CITY OF ALBUQUERQUE

**Re: Project Orion
Gibson Blvd at Girard Blvd SE Quadrant
Draft Report Phase 1
Dated September 2020, received 9/24/2020**

I have reviewed the Project Orion Phase 1 draft initial submittal. Additional comments from other City Transportation reviewers are expected soon and will be provide when ready. Please address the follow comments:

Site Location

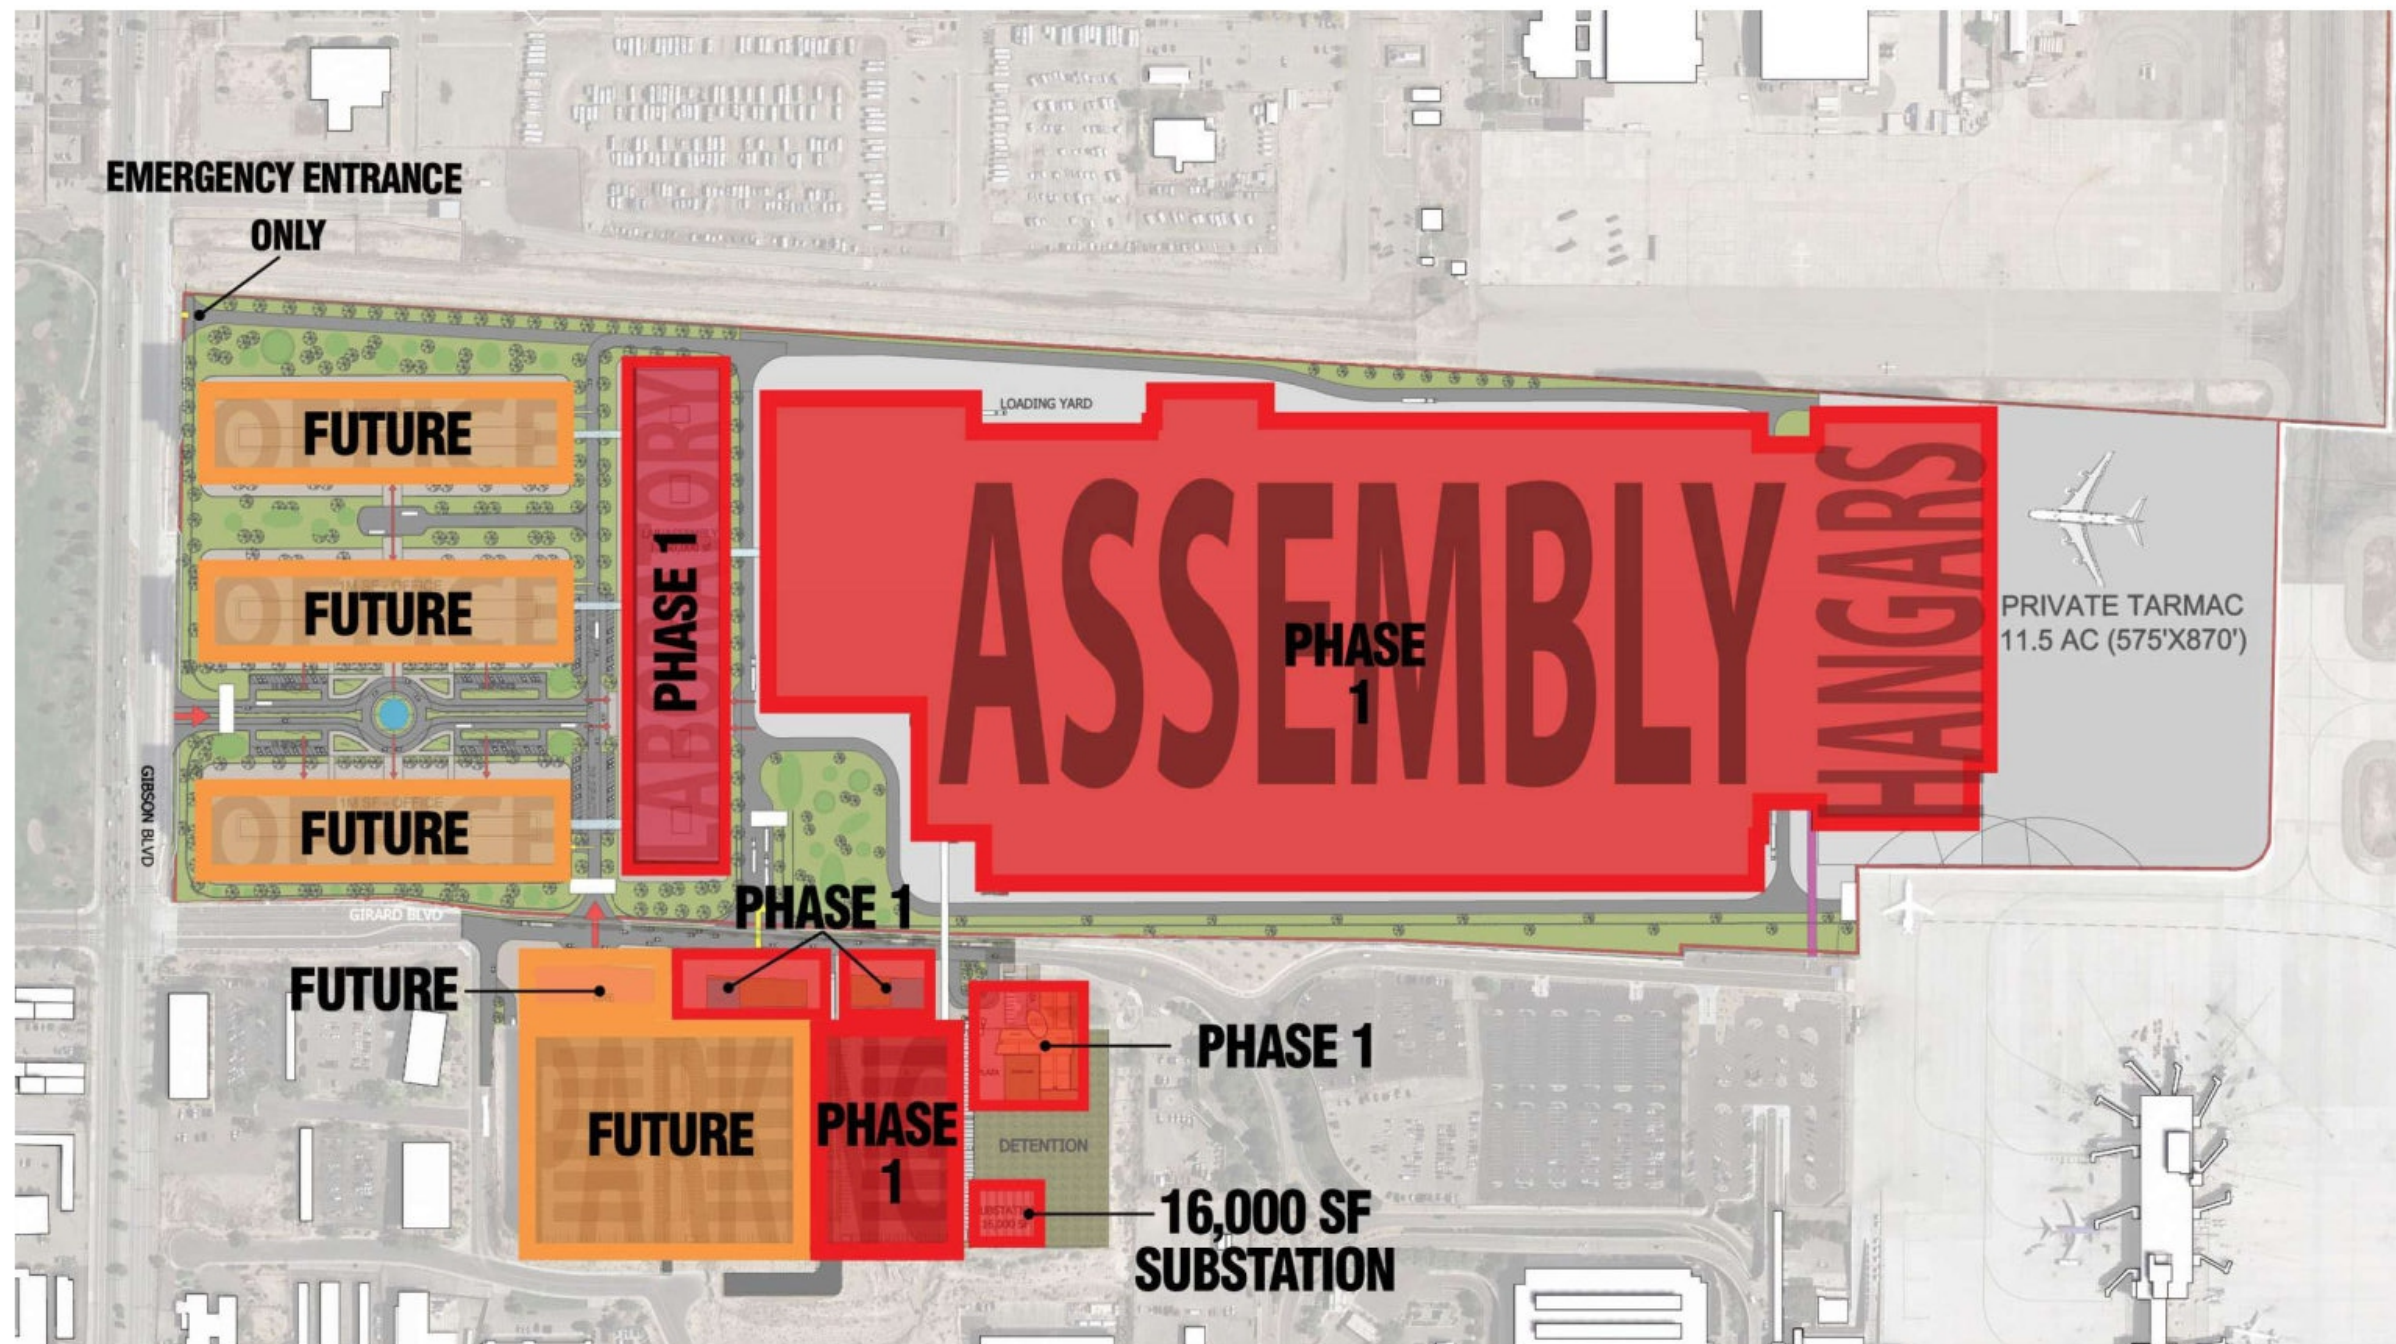
1. Include an exhibit with emphasis on access points showing driveway locations, number of lanes and access/turning restrictions.
2. Sunport Blvd. through the AIS will require access control improvements reducing the pedestrian conflict points and increasing the speed limit. The road alignment should be improved to provide efficient operation with minimal access points.
